KITTITAS COUNTY

DEPARTMENT OF PUBLIC WORKS

MEMORANDUM

TO: All Staff
FROM: Public Works Plan Review Team
DATE: April 18, 2024
SUBJECT: SP-24-00005 Mohar

MOHAR FARM SHORT PLAT

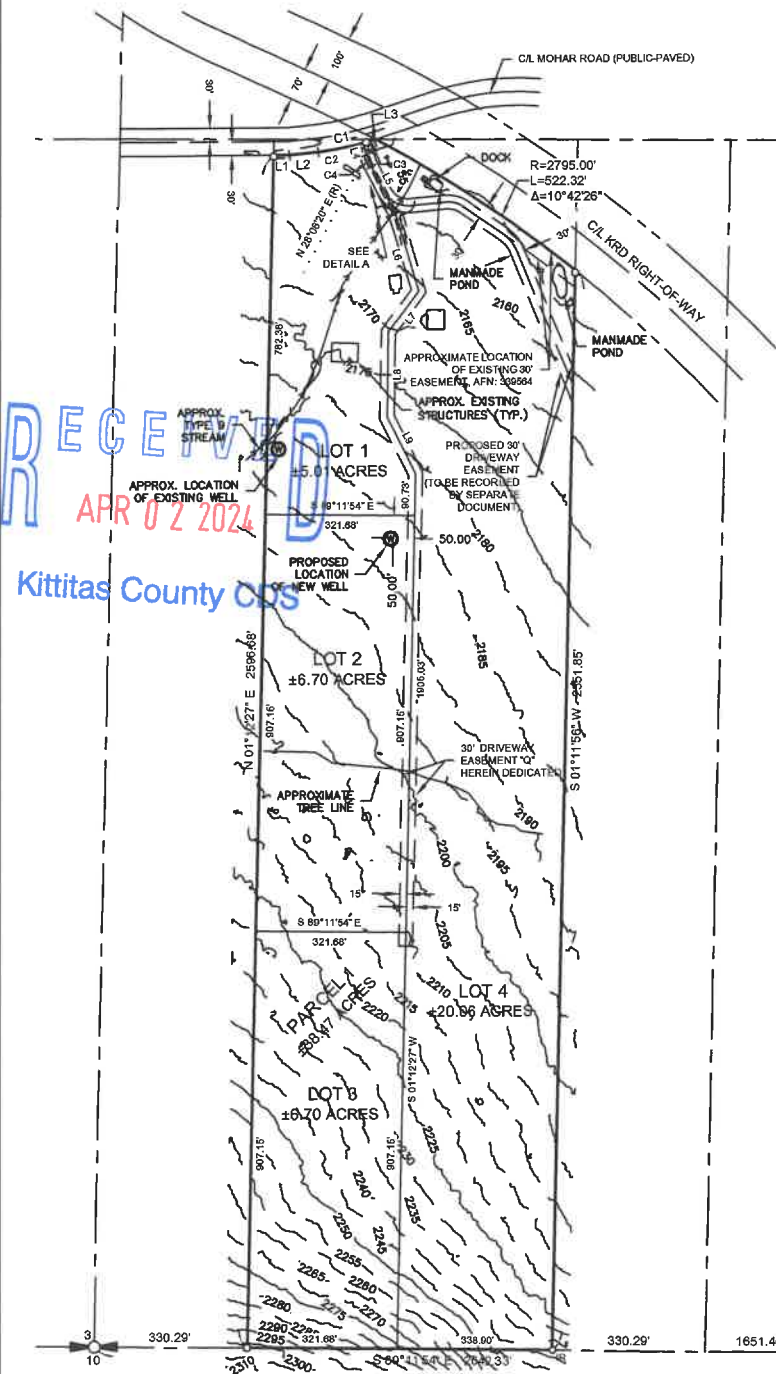
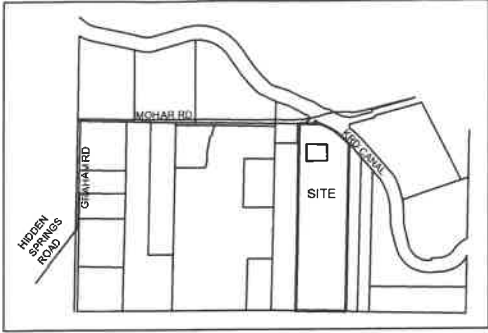
SURVEY	<ol style="list-style-type: none"> 1. All survey documents (including prelim Plats and Short Plats), must be prepared, stamped, and signed by a surveyor licensed in the State of Washington. 2. Topo standard requirements per WAC 332-130-145 need to be addressed. 3. The basis of bearing needs to be identified. <p>OF NOTE</p> <p>While not required for prelim, the following elements will need to be addressed on the final Short Plat:</p> <ol style="list-style-type: none"> 4. A current title report will need to be provided. 5. Property corners will need to be shown on the new division lines. 6. The section corners will need to be labeled as found or calc, together with a description. (JT)
TRANSPORTATION CONCURRENCY	No transportation concurrency management application is required for this project. (KAH)
FLOOD	Parcels 14362, 19296, and 205534 are not located in the FEMA mapped special flood hazard area (100-year floodplain). A floodplain development permit is not required for the proposed project. (SC)
